Viola Patrick R III & Steve R III
CITY OF PORTLAND
Build room over garage/home renovation

AT 348 Palmer Ave

City of Portland, Maine - Building or Use Permit

Dept: Building **Status:** Approved with Conditions **Reviewer:** Tammy Munson **Approval Date:** 06/17/2005
Note: **Ok to Issue:**

PROPOSED GARAGE STRUCTURAL DETAIL

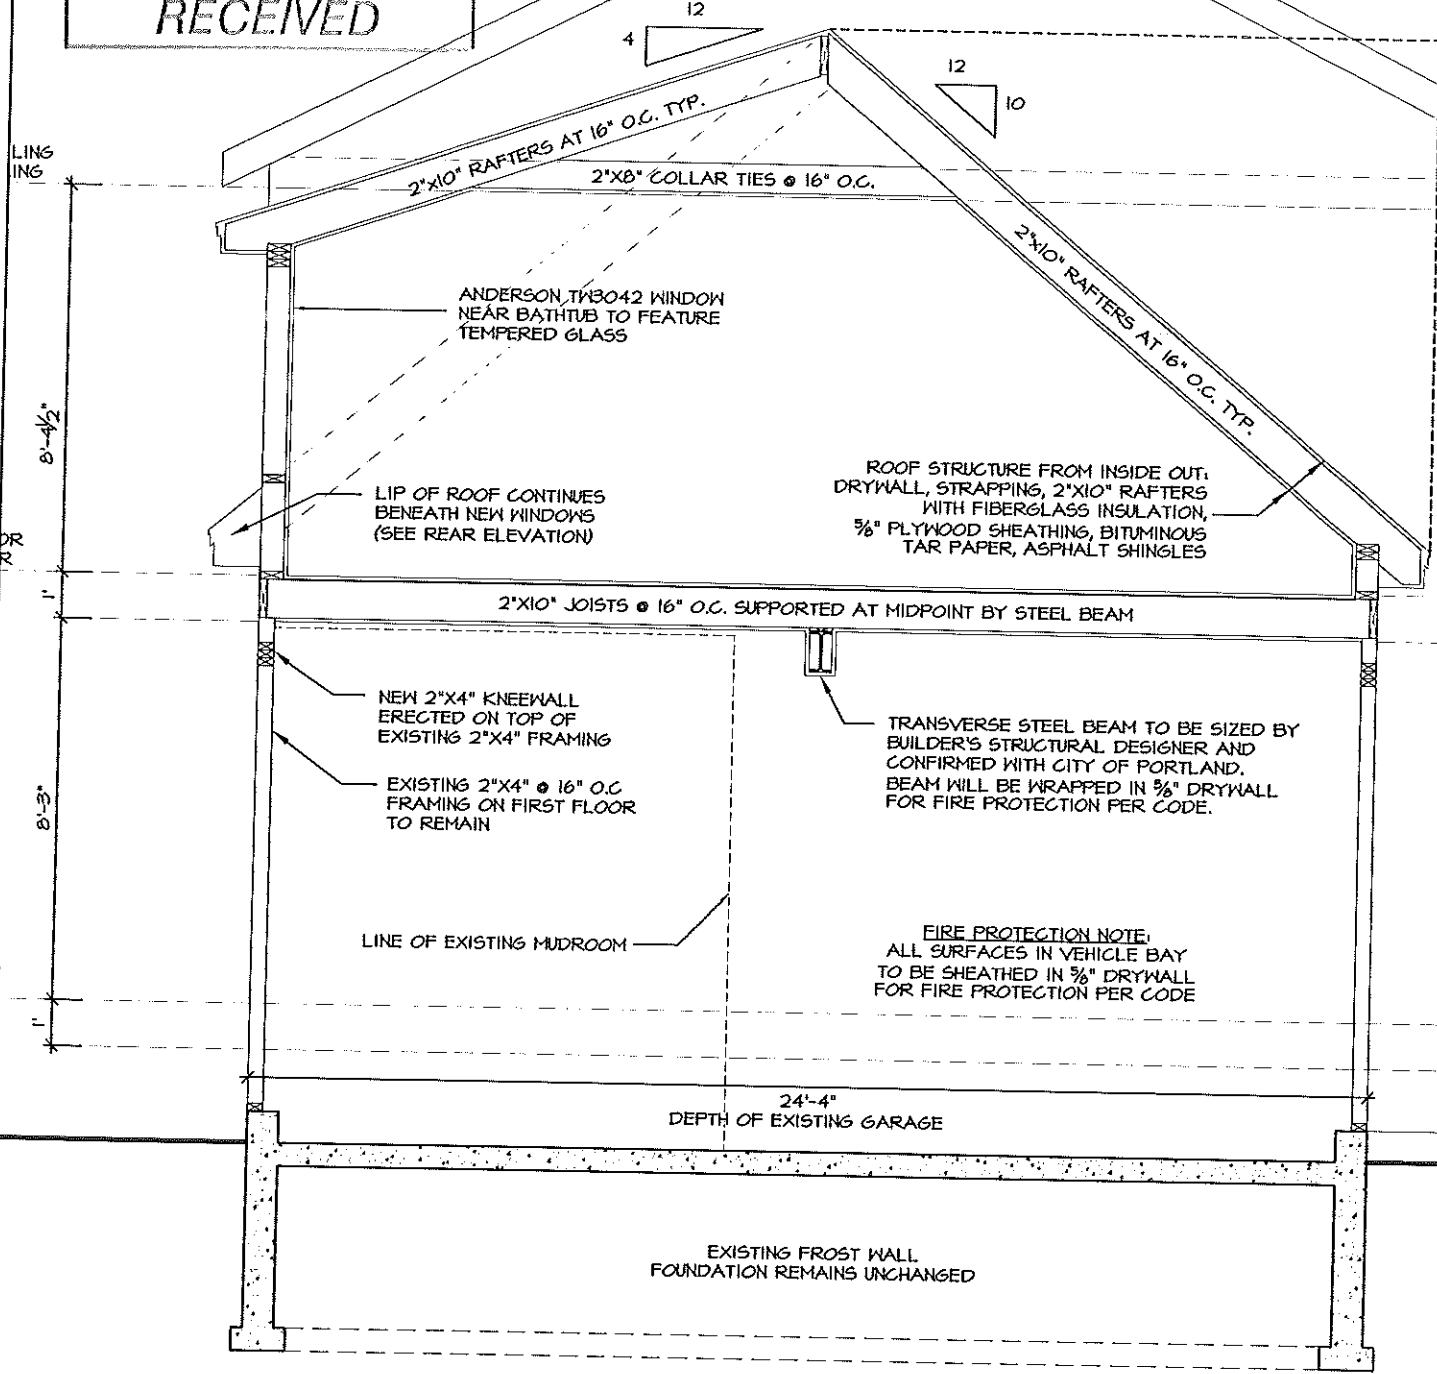
Also attached is a drawing that changes the 2"x6" kneewall to a 2"x4" kneewall to match the first floor framing, as you requested.

2"x6" KNEEWALL ON TOP OF EXISTING
FIRST FLOOR FRAMING HAS BEEN CHANGED
TO  A 2"x4" KNEEWALL PER DIRECTION
OF CITY OF PORTLAND

**Roof Plan,
Framing Plan,
Window Sched.**

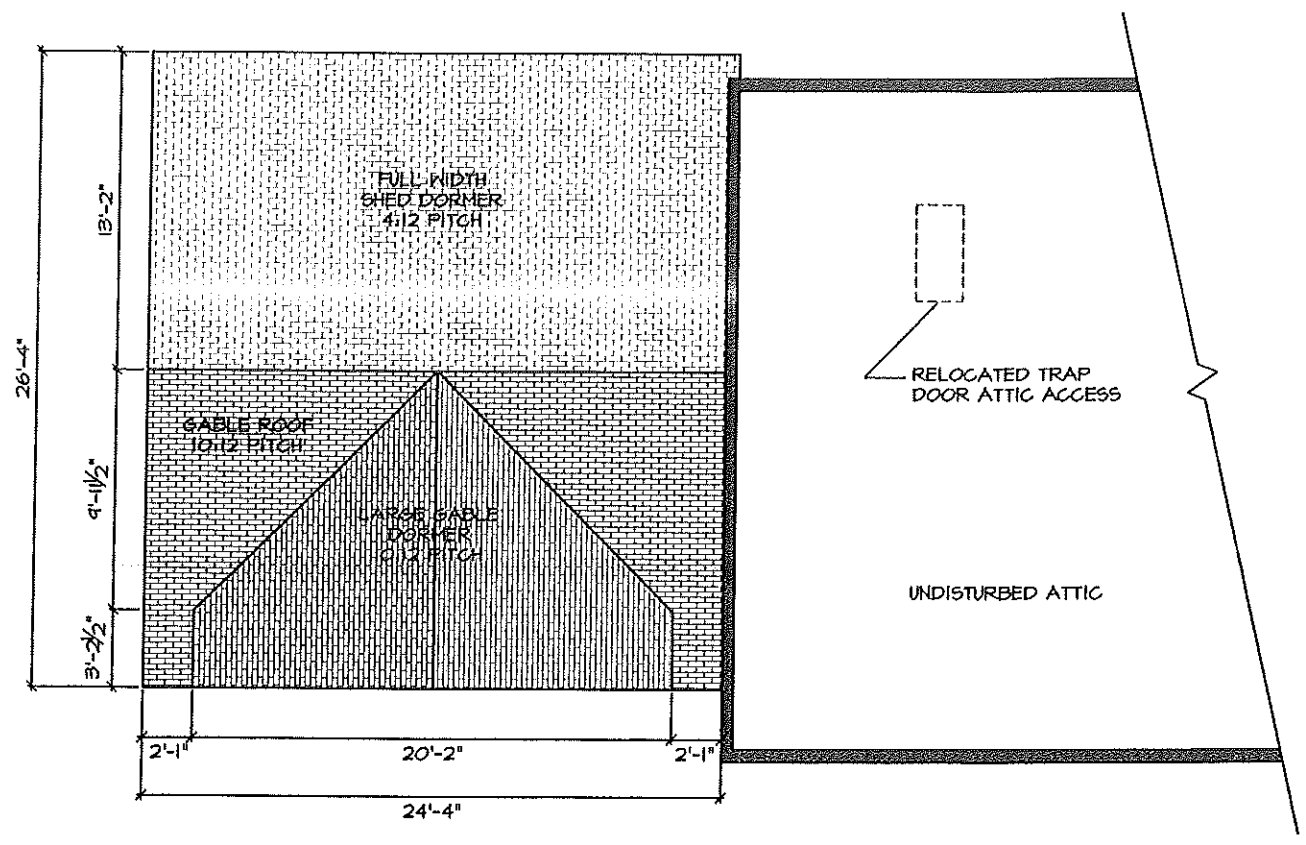
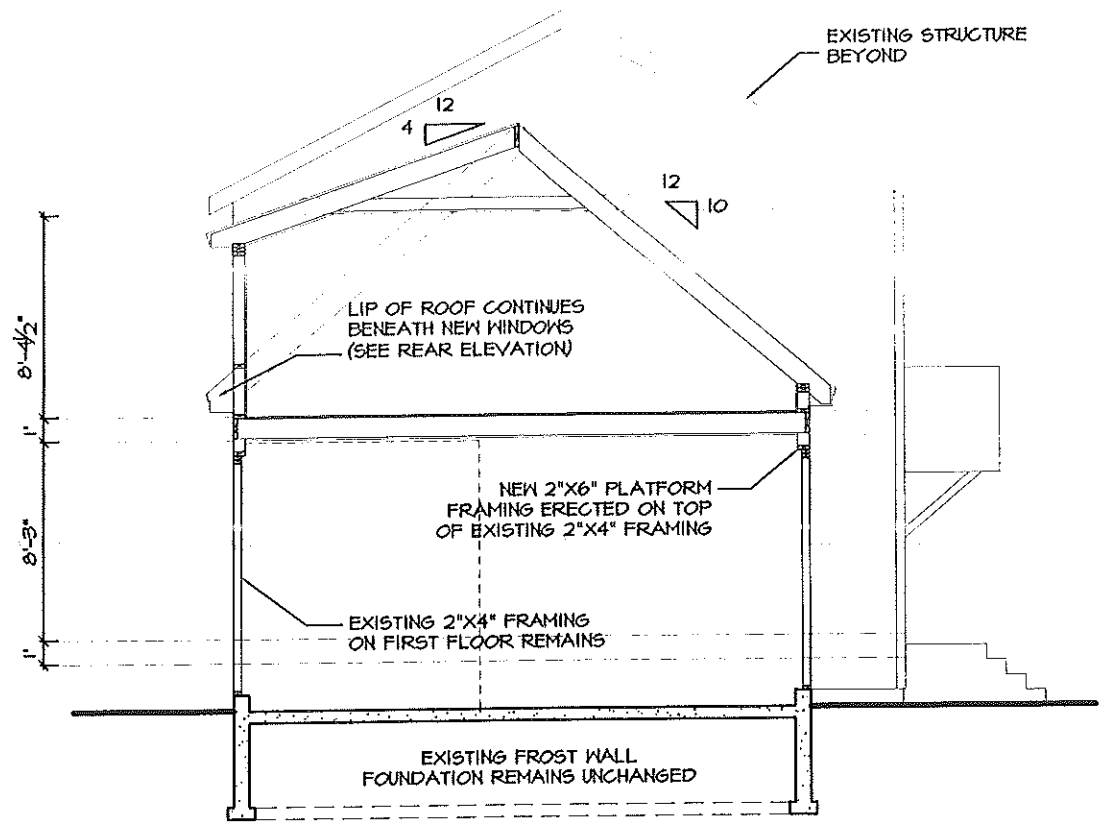
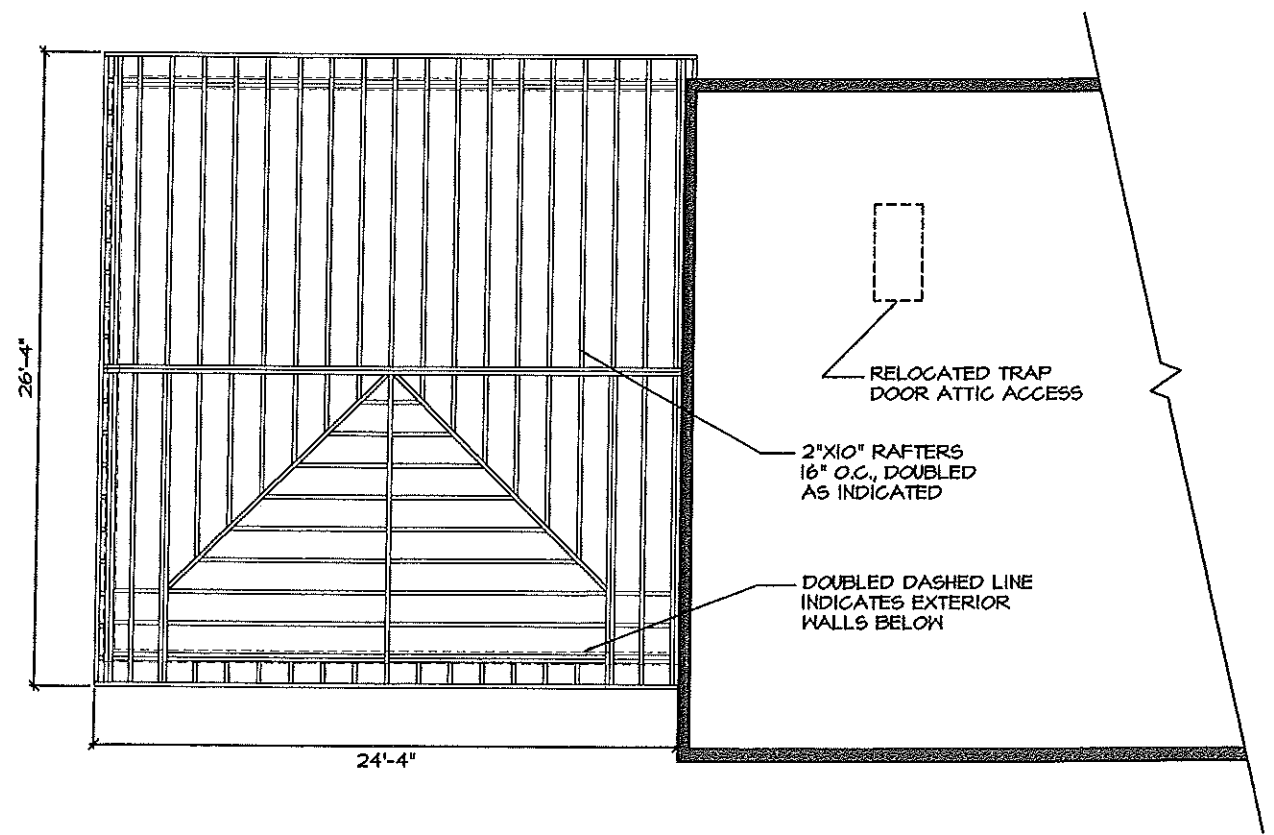
Thanks for your call today. I just spoke with the builder, Steve Brann, and got the info on the headers. I have pasted the window schedule from Drawing #10 the drawing set into this e-mail, and have added the header info for each window.

1. QTY: 1 ANDERSON TW3042 R. O. = 3'-2-1/8"w X 4'-4-7/8"h ✓
Header = 3 of 2"x6", length to span rough opening and bear on jack studs.
2. QTY: 1 ANDERSON TW3046-2 R. O. = 6'-3-15/16"w X 4'-9-1/4"h ✓
Header = 2 of 2"x10", length to span rough opening and bear on jack studs.
3. QTY: 1 ANDERSON TW3042-3 R. O. = 9'-5-3/4"w X 4'-5-1/4"h ✓
Header = 3 of 2"x6" bearing on vertical studs between window units and jack studs at ends.
4. QTY: 1 ANDERSON P3030 R. O. = 3'-0-1/2"w X 3'-0-1/2"h

Header = 2 of 2"x8", length to span rough opening and bear on jack studs. ✓

Header = 2 of 11-7/8" L.V.L.s, length to span rough opening and bear on jack studs.
